Arun District Council
Arun Civic Centre
Maltravers Road
Littlehampton
West Sussex BN17 5LF
Planning General Enquiries
Tel: (01903) 737756 Fax: (01903) 730442
Dx: 57406 Littlehampton
Minicom: 01903 732765
e-mail: planning@arun.gov.uk
website: www.arun.gov.uk/planning

Your Ref: LU/167/18/DOC

11 September 2018

Town & Country Planning Act 1990 (as amended)
Town and Country Planning (Development Management Procedure) (England) Order 2015
Approval of details reserved by condition imposed under LU/251/15/PL relating to conditions 3-
schedule & samples of materials & finishes, 4-landscape scheme, 5-waste storage, 6-surface water
drainage, 8-materials for boundary fences & gates, 10-bicycle storage & 11-vibration assessment.
1 Tulley Cottages Toddington Lane, Littlehampton,

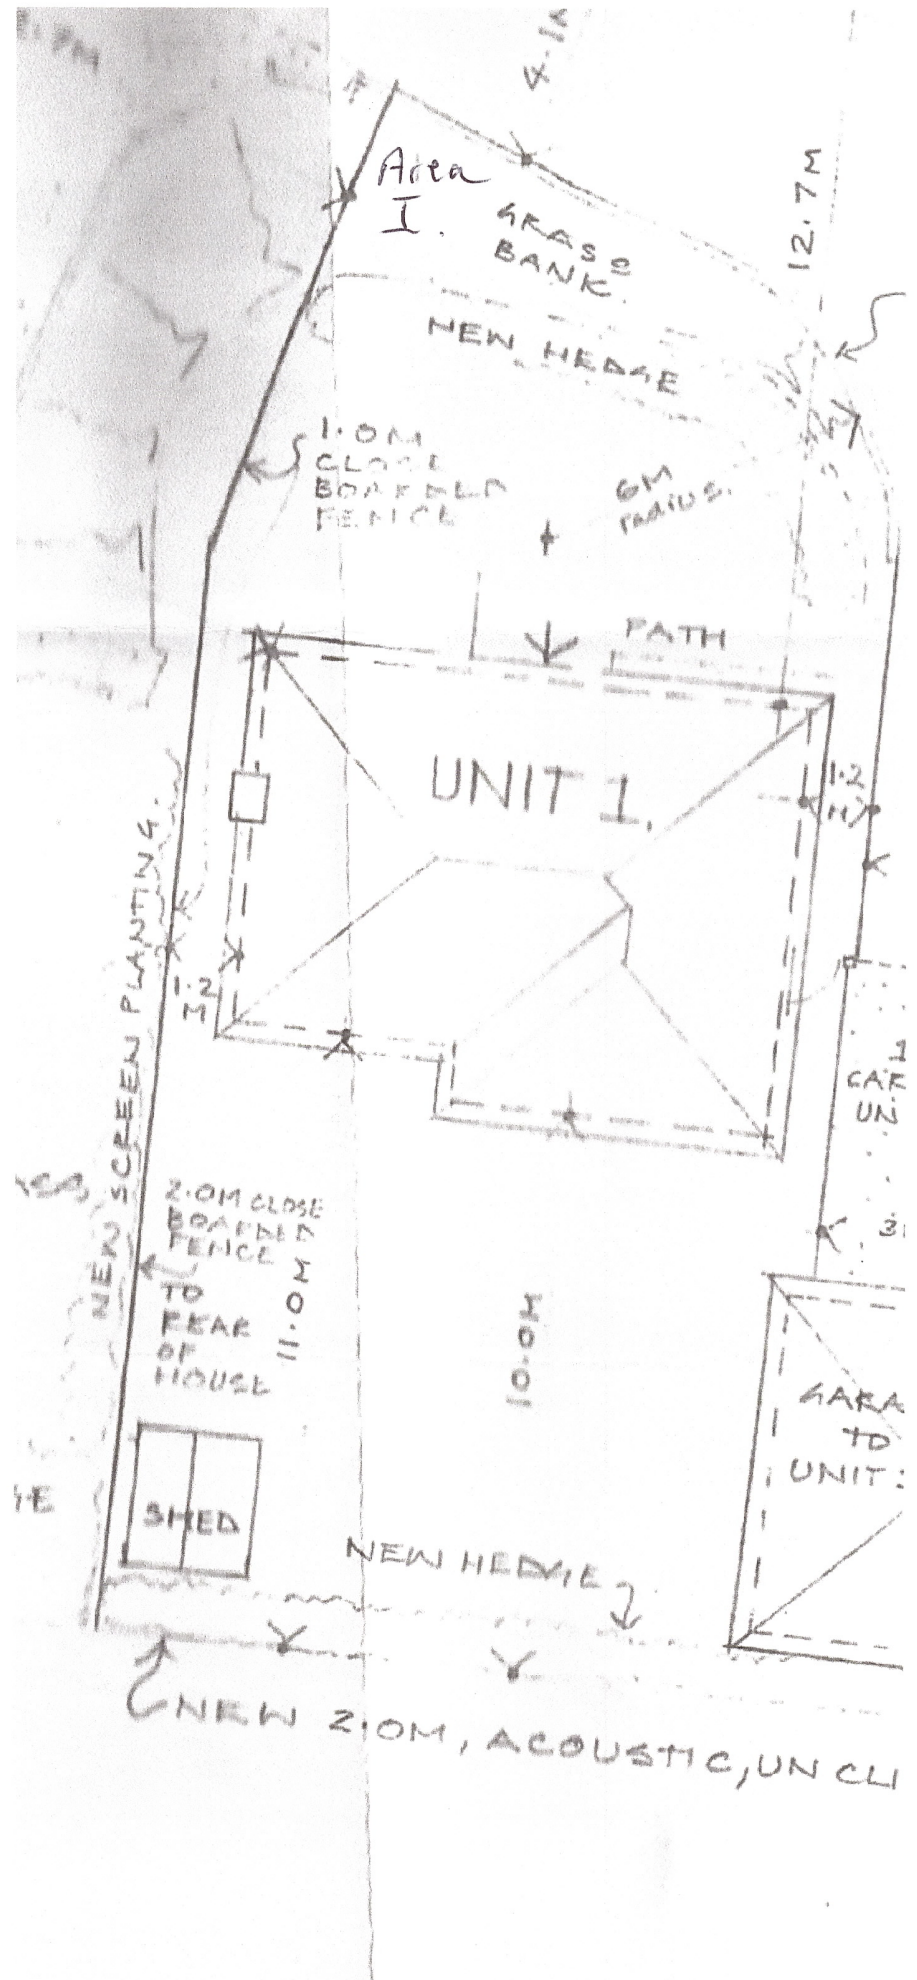
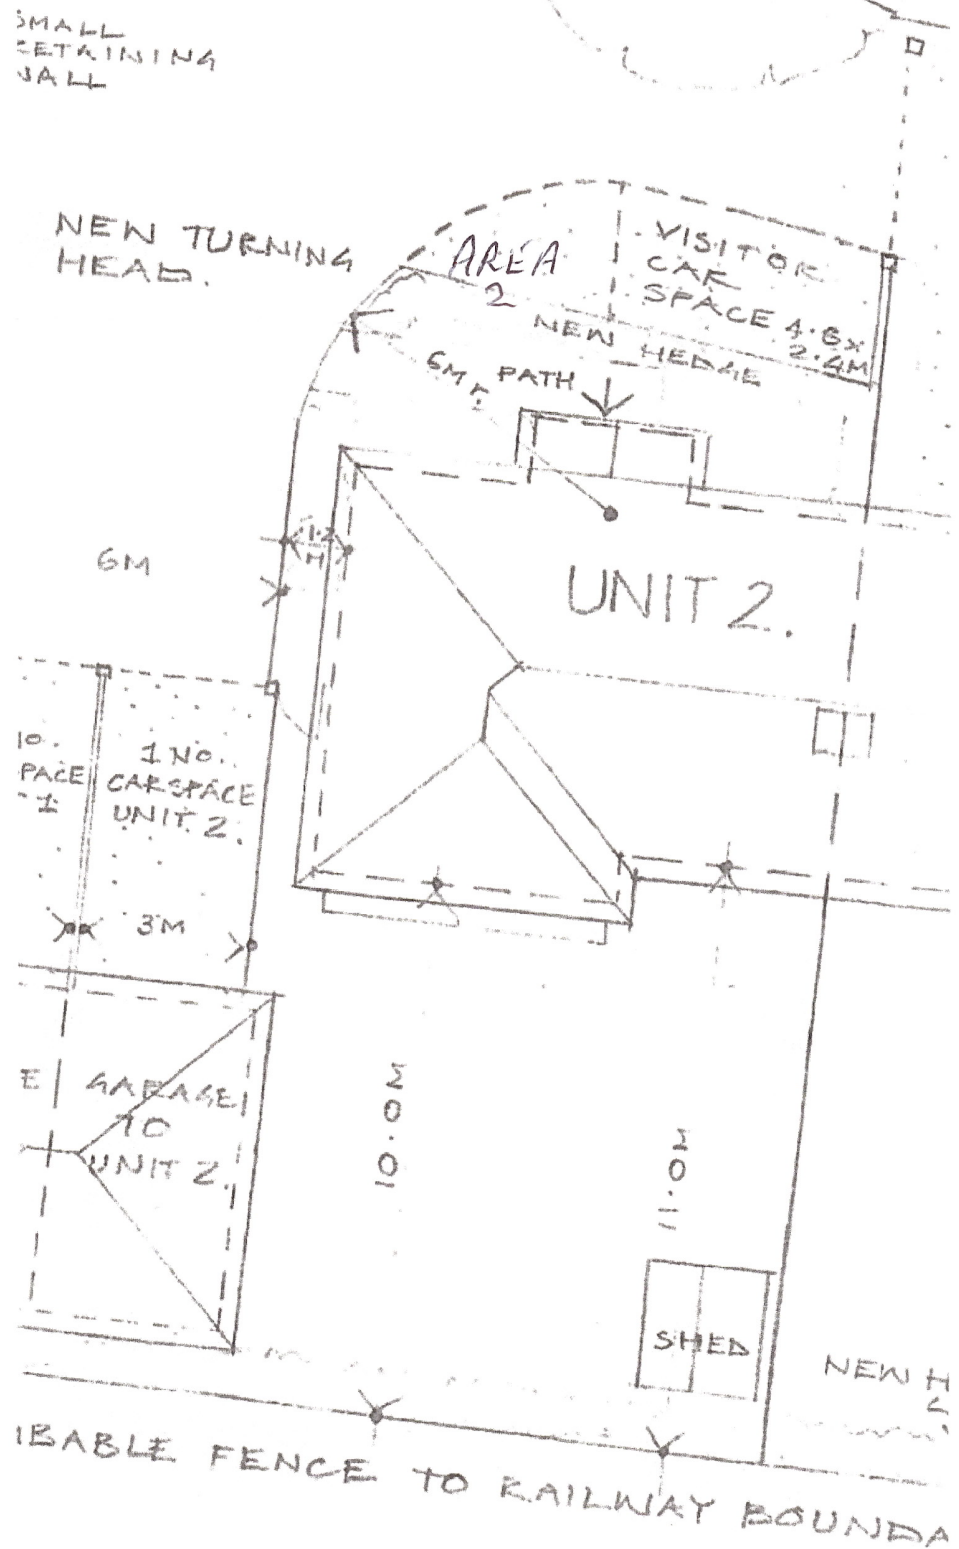
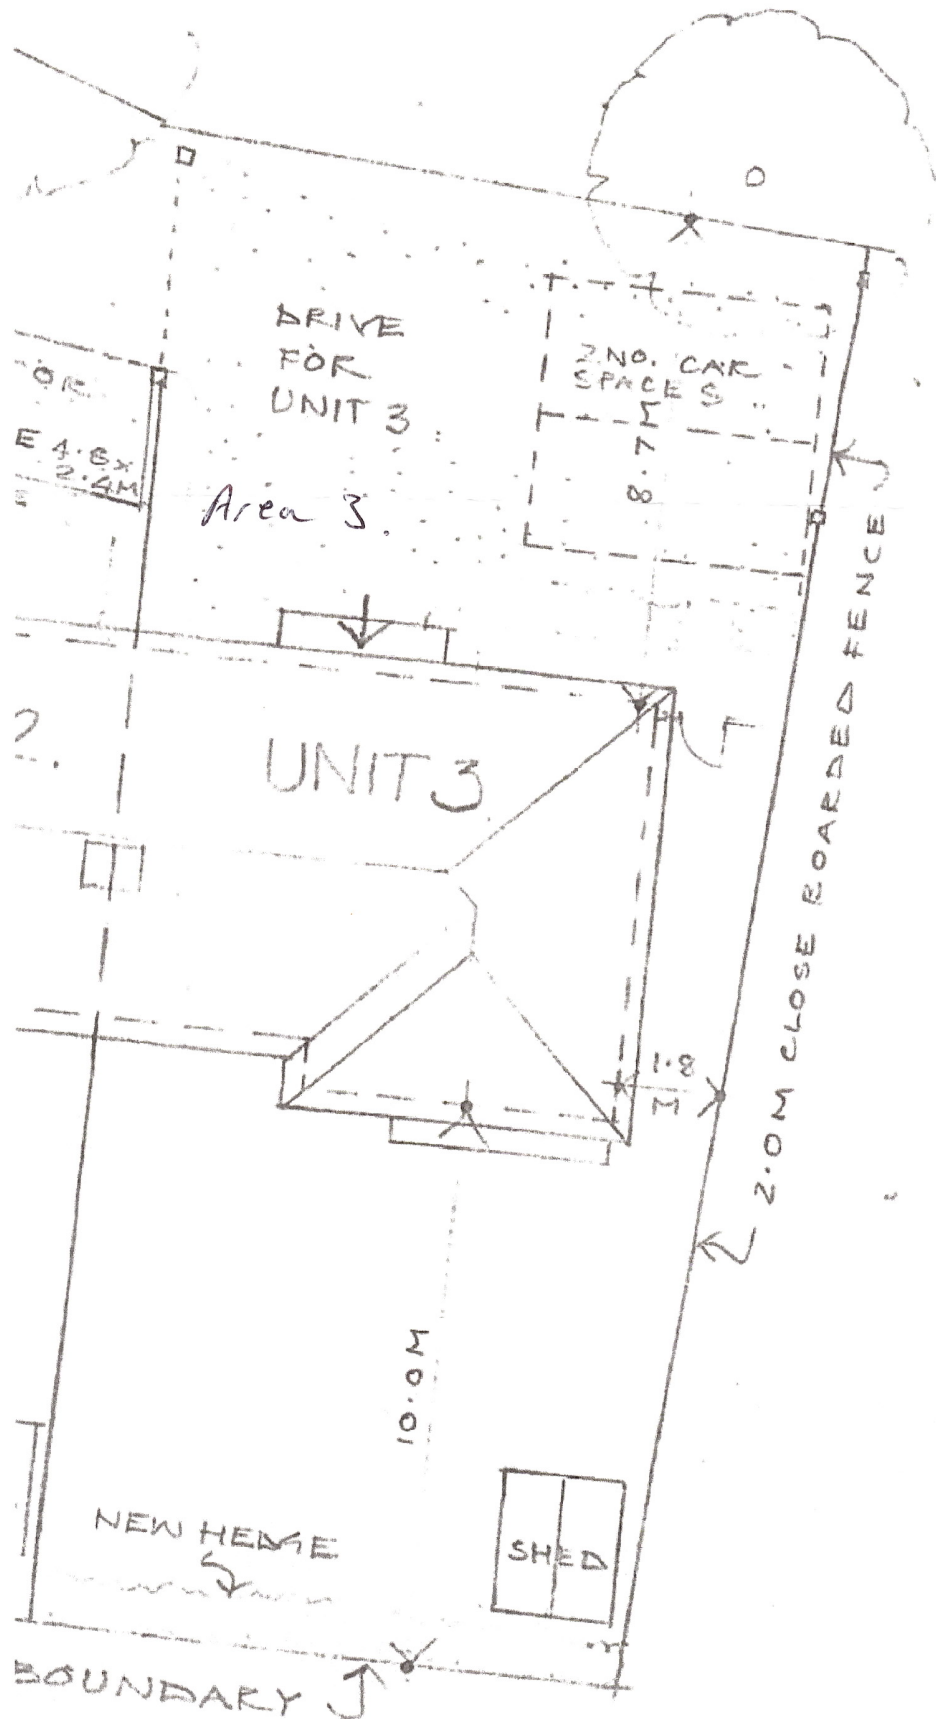
The information submitted under drawing headed Landscape Plan areas 1,2,3 does not provide clear or adequately detailed information re species choice, actual numbers proposed and size at time of planting. These need to be shown clearly indicated in the planned location areas. The drawing refers also to new hedge, which does not appear to have been detailed with the above information.
